M & R HOSIER – REP: 20020373 - COMMENTS ON OEMP ANNEX A4 – ILLUSTRATIVE EXAMPLES OF KEY DESIGN ELEMENTS [REP7-024]

Drawing Title
STRUCTURES DRAWINGS
WESTERN TUNNEL PORTAL
REGULATION 5(2)(o)
SHEET 8 OF 13

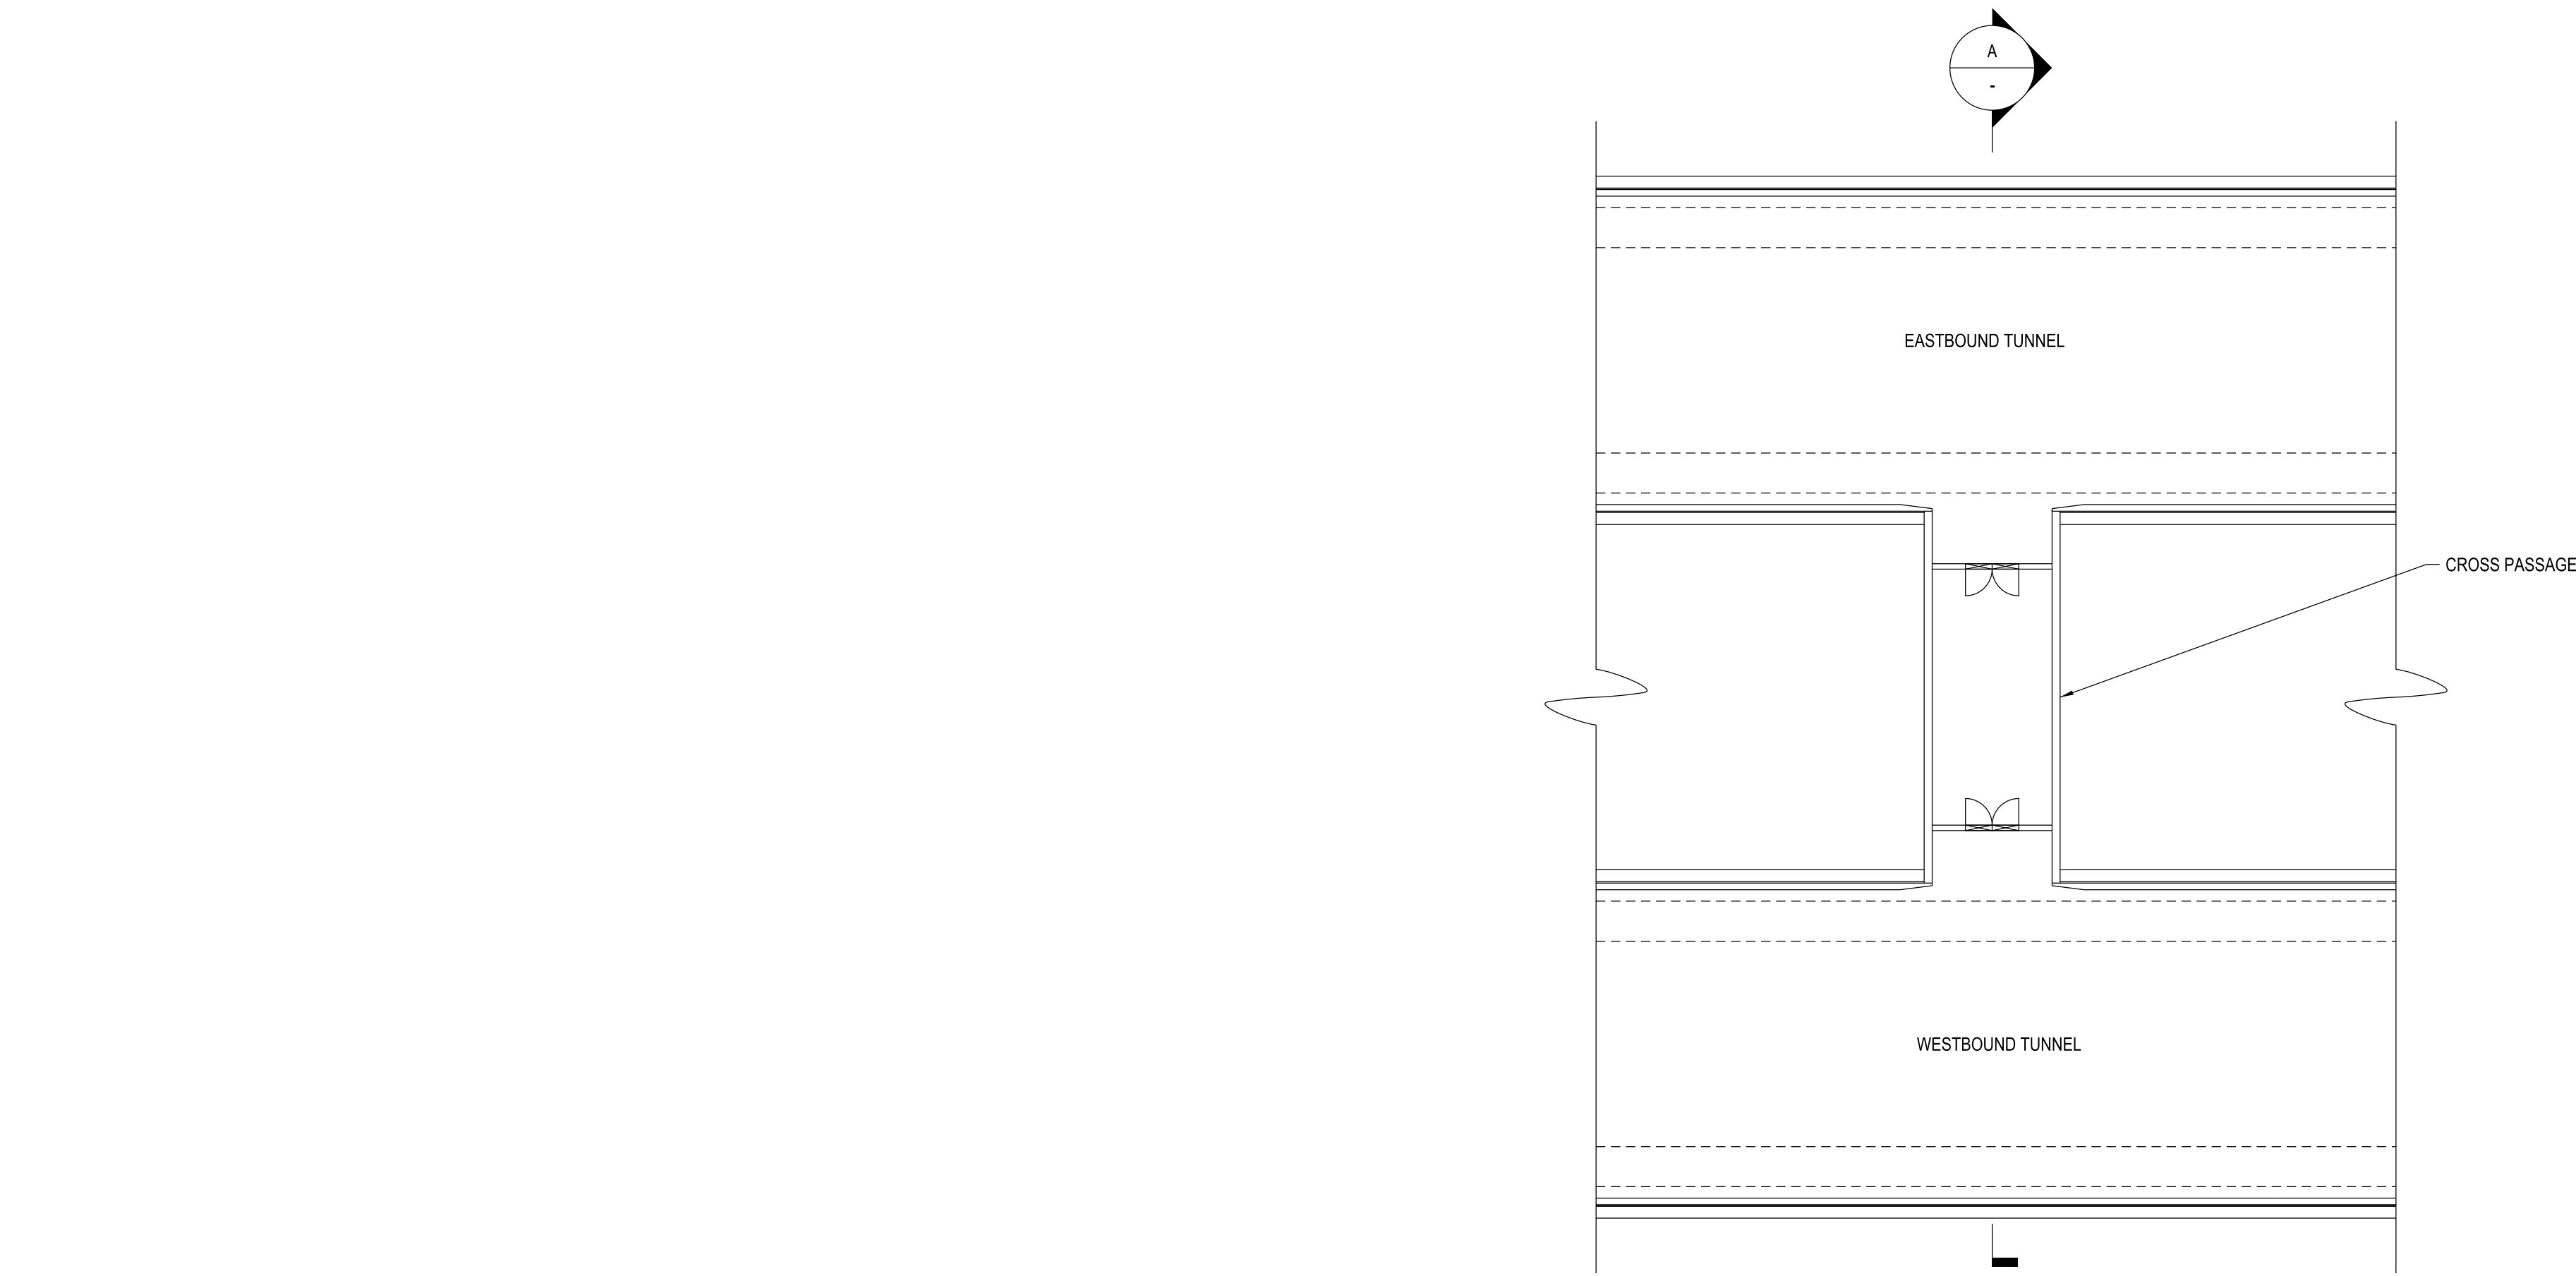
There seems to be a poor representation of the contours of the landscape. The location of the current A303, (or future PRow), is also not well depicted within the drawing. The vast difference in height between the PRow on a higher level, with the natural ground level of the portal is not readily apparent. From the height of the PRow and its close proximity to the portal, there would be a view not only of the sidewalls, but probably of the carriageway as well.

We did ask for a drawing for the PRoW on the line of the A303 in the location of the western portal, but the Applicant has not provided one. We made this request, as from this location we believe there will be clear views of traffic emerging from the portal.

We do not think the sidewalls and parapet of the cutting are in harmony with the surroundings or in keeping with the WHS. How will “*earthy tones*” on manmade structures blend into the existing chalk grassland with livestock and rolling arable fields with crops? There are no long linear manmade concrete structures within the WHS other than the existing A303, so we do not see the road in a cutting to be an improvement on the current setting.

We are unsure about the depiction of the drawing, as the mouth of the western portal seems to be shown in the middle of the length of cutting rather than at the far end by Normanton Gorse Wood?
